**Development Review Board (DRB)
Review Comments
Utility Development Section
Reviewer: Kristopher Cadena, P.E.
Phone: 505.289.3301**

DRB Project No: PR-2019-003077	Date: 01/08/2020	Item No: #5
Zone Atlas Page: H-19	Legal Description: Lot(s) TR 6-A-1-C-1-A BLK C PLAT FOR LOTS 5-A-1, 5-A-2, 6-A-1-C-1-A AND 6-A-1-C-1-B BLOCK "C", LOUISIANA SUBDIVISION Location: 2424 LOUISIANA BLVD NE	
Request For: SI-2019-00370 – SITE PLAN VA-2019-00426 - WAIVER

SITE PLAN

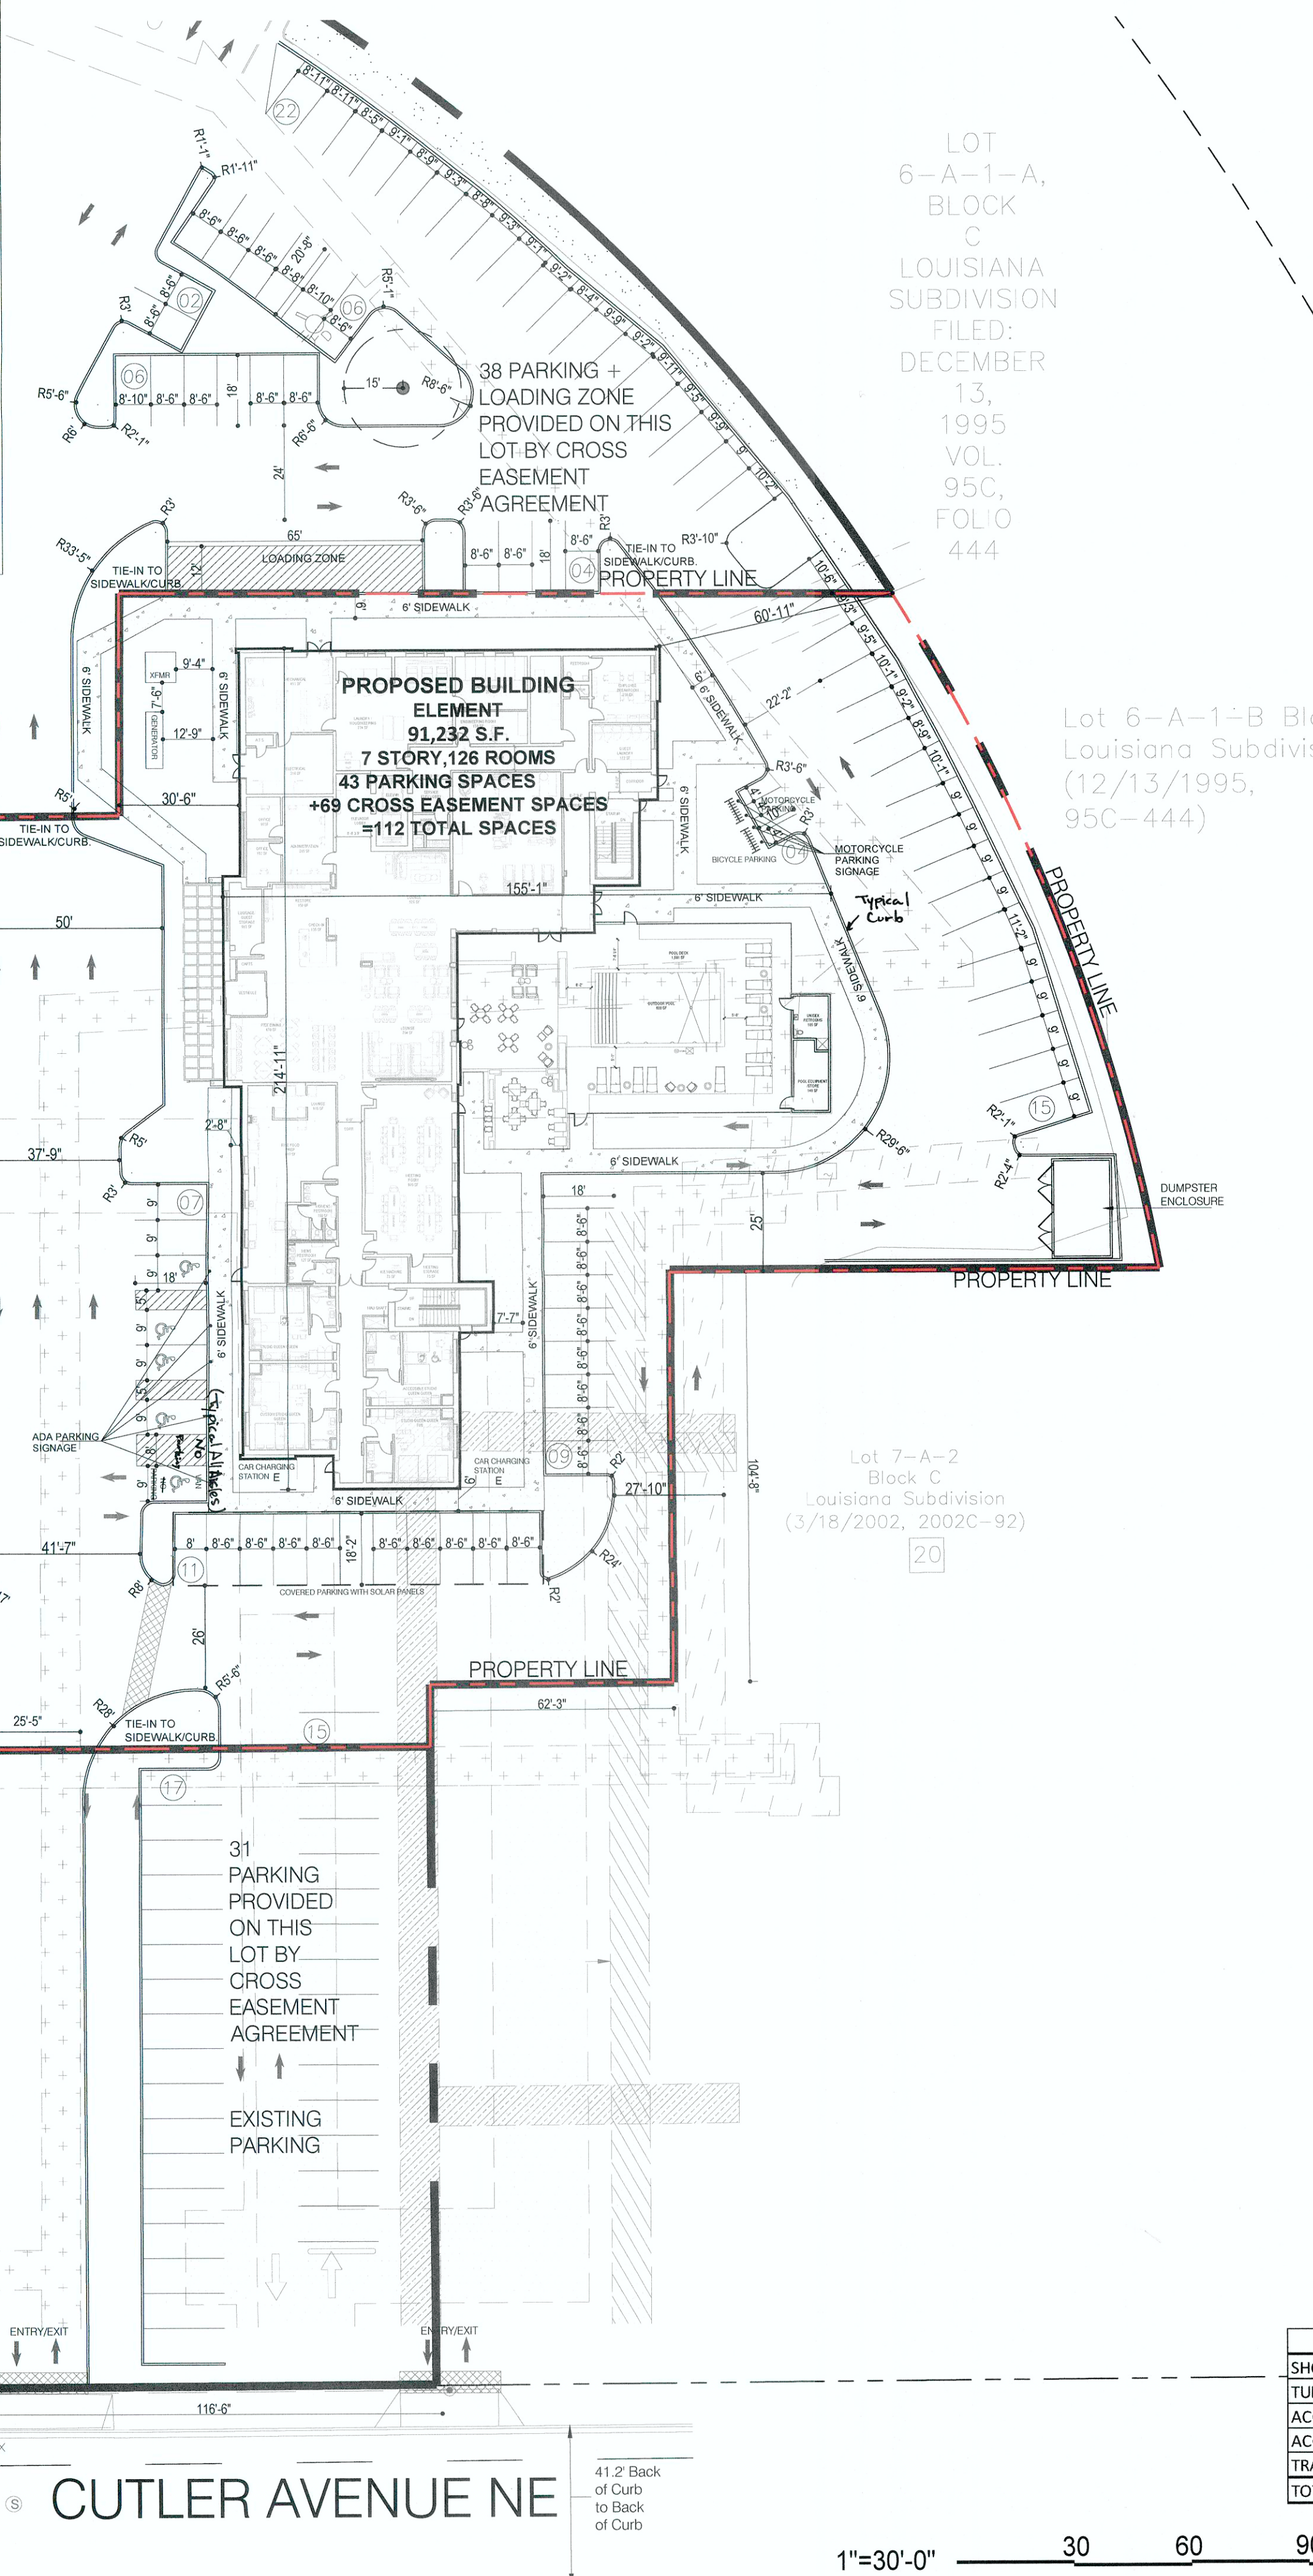
1. Availability statement 191102 has been requested and will provide conditions for service.
 - a. An executed availability statement is required prior to approval.
2. The proposed site plan shows metered service and a private fire suppression line from an existing private fire line:
 - a. Metered service shall be taken from a public water distribution main.
 - b. Each lot shall have separate fire lines.
3. The proposed Fire 1 plan shows existing private fire hydrants being utilized. The developer should confirm if this is allowable and if documented with an easement/covenant to be shared use and maintenance.
